SSD 6011 - Mixed use residential development within the South West Plot

Submission by:

Graeme Johnson

31 July 2013

Winter Solstice 9am

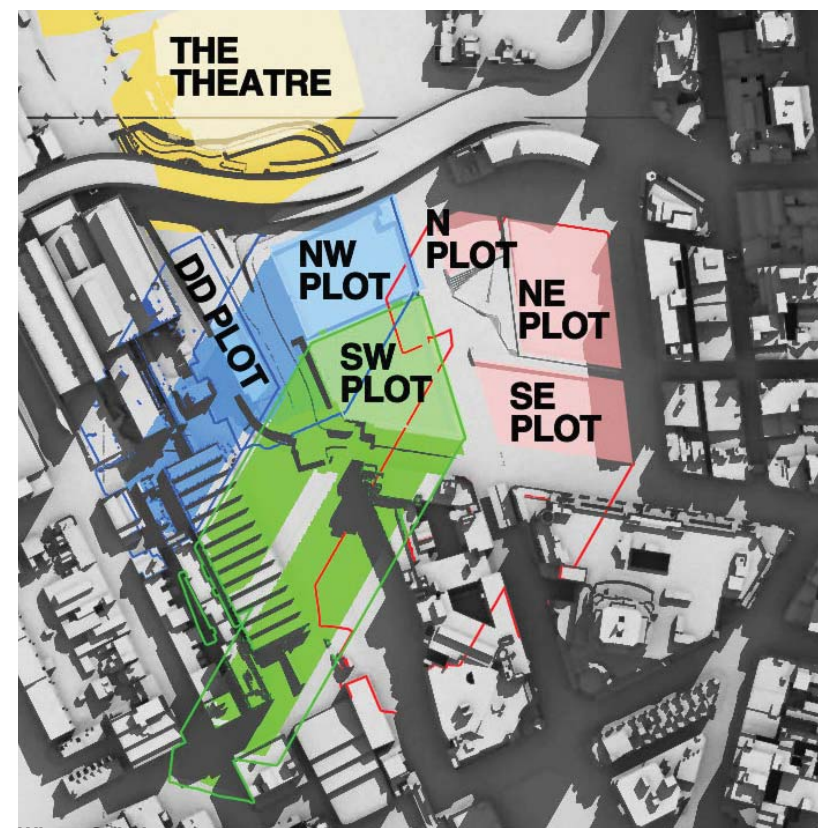
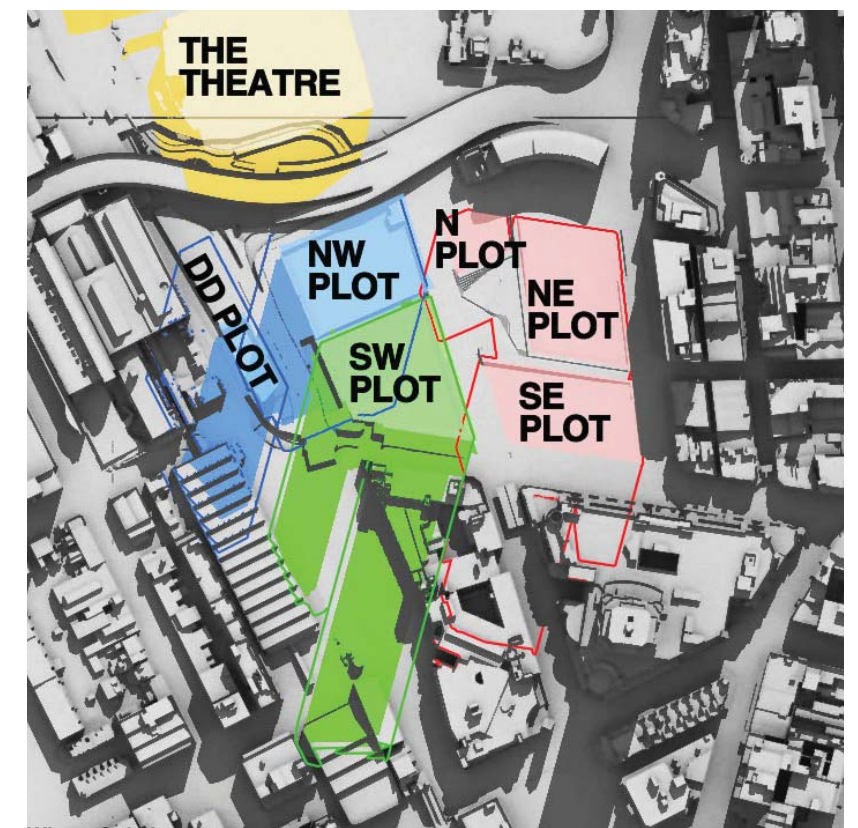
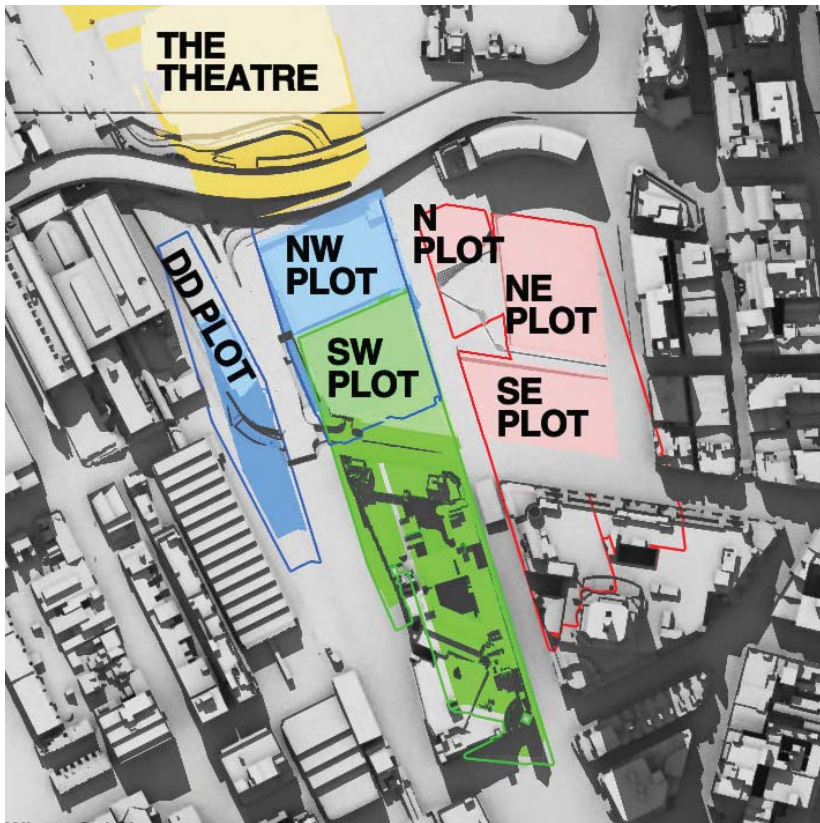
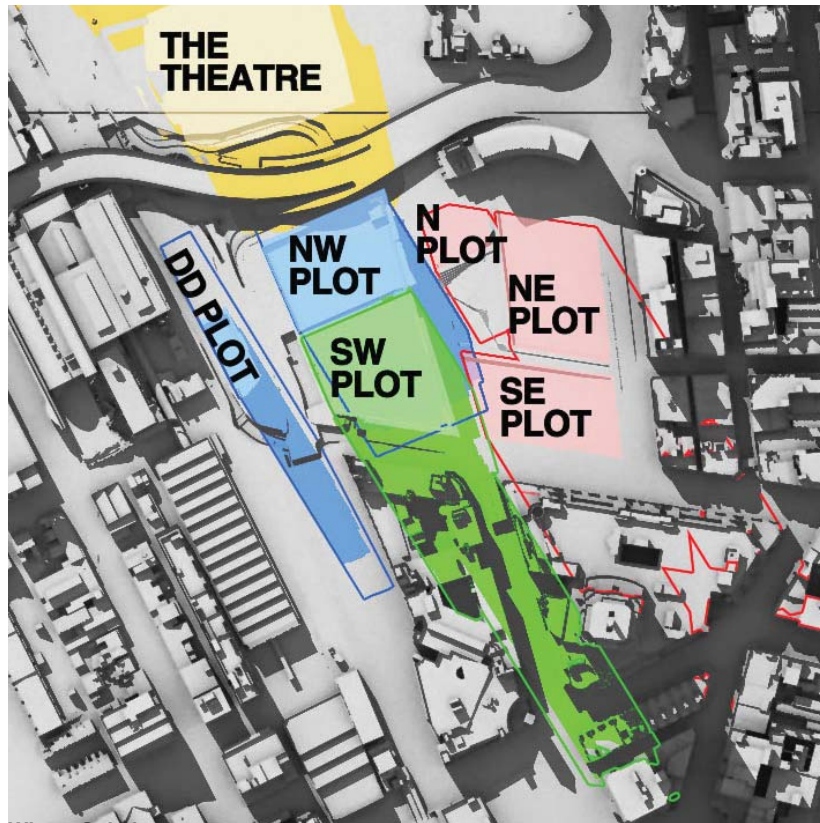
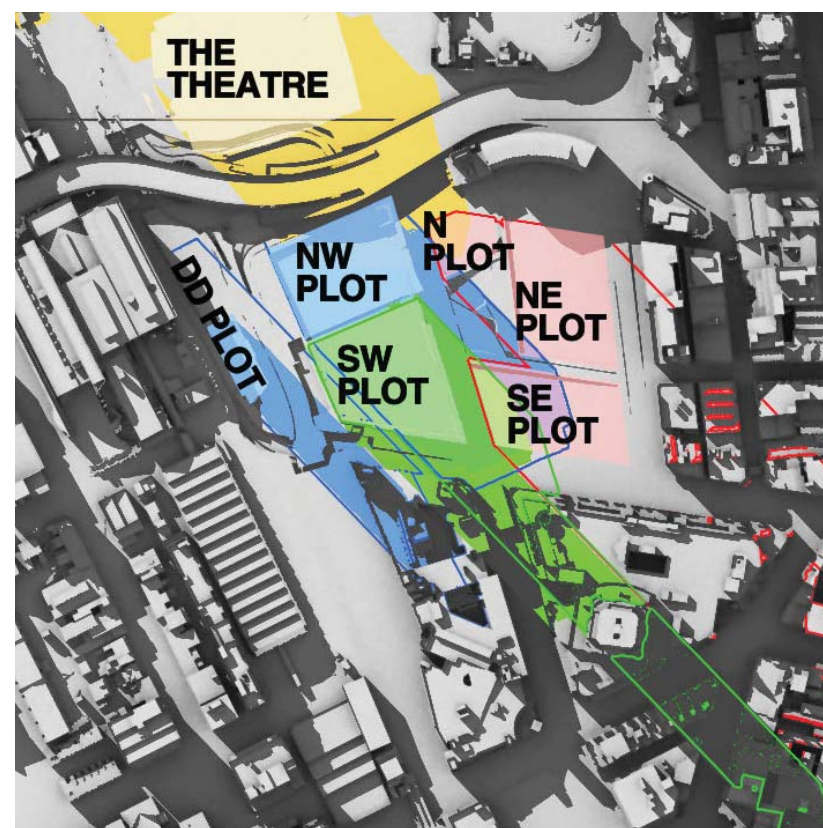
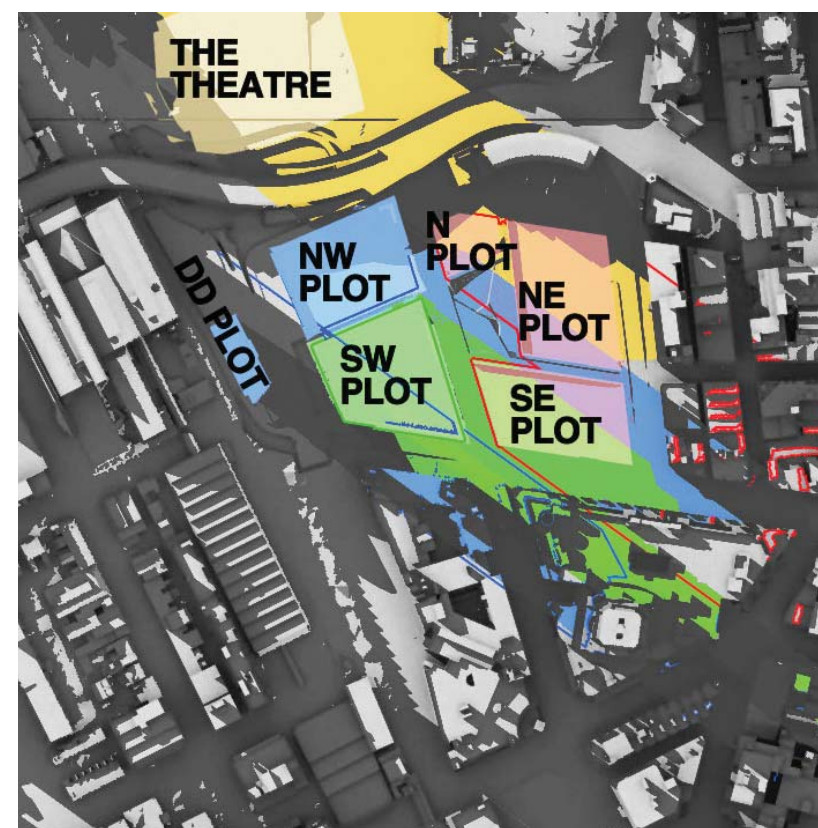
We refer to the shadow diagrams in SSD5878, Appendix H. Supplementary Design Report, Section 6. Amendments, Winter solstice - 22 June. This is not 21 June, but there would be no noticeable difference.

At 9am, 10am and 11am the west façade is totally in shadow due to other parts of The Peak building itself.

At 12pm there is still substantial existing shadowing on the west façade caused by the irregular shape of the west facade.

At 1pm the existing shadowing has been substantially removed, but not totally removed.

It can be concluded that some single aspect apartments on the west façade and some south-west dual aspect corner apartments currently receive less than 2 hours direct sunlight to habitable rooms and 50% of the private open space between 9am and 3pm on 21 June.

By 2pm the existing shadowing has been totally removed, but that is too late to achieve two hours of direct sunlight before 3pm.

At 9am, 10am and 11am the west façade is totally in shadow due to other parts of The Peak building itself.

At 12pm there is still substantial existing shadowing on the west façade caused by the irregular shape of the west facade.

At 1pm the existing shadowing has been substantially, although not entirely, removed. However, overshadowing of lower levels of the west façade by the concept proposal parameter plan shadows for the N,NE and SE plots has already started.

By 2pm the existing shadowing has been totally removed. However, overshadowing of the west façade by the SSDA4 and SSDA5 buildings has appeared and risen further up the west façade than the concept proposal parameter plan shadows for the N,NE and SE plots, which is still present.

At 3pm, the proponent states correctly that 45-45% of the western façade is overshadowed by the SSDA4 and SSDA5 buildings.

It can be concluded that, as a result of combination of the proposed development with existing shadowing of the west façade, some single aspect apartments on the west façade and the south-west dual aspect corner apartments which currently receive less than 2 hours direct sunlight to habitable rooms and 50% of the private open space between 9am and 3pm on 21 June will suffer additional overshadowing. It is beyond our skills to count the number of such apartments. We note that the proponent has made no attempt to do so.

Rather than counting the number of units which will not meet the DCP guidelines, the proponent attempts to trade-off direct sunlight at 4pm for lack of direct sunlight during the period 9am to 3pm. There is no provision in the DCP guidelines for such a trade-off.
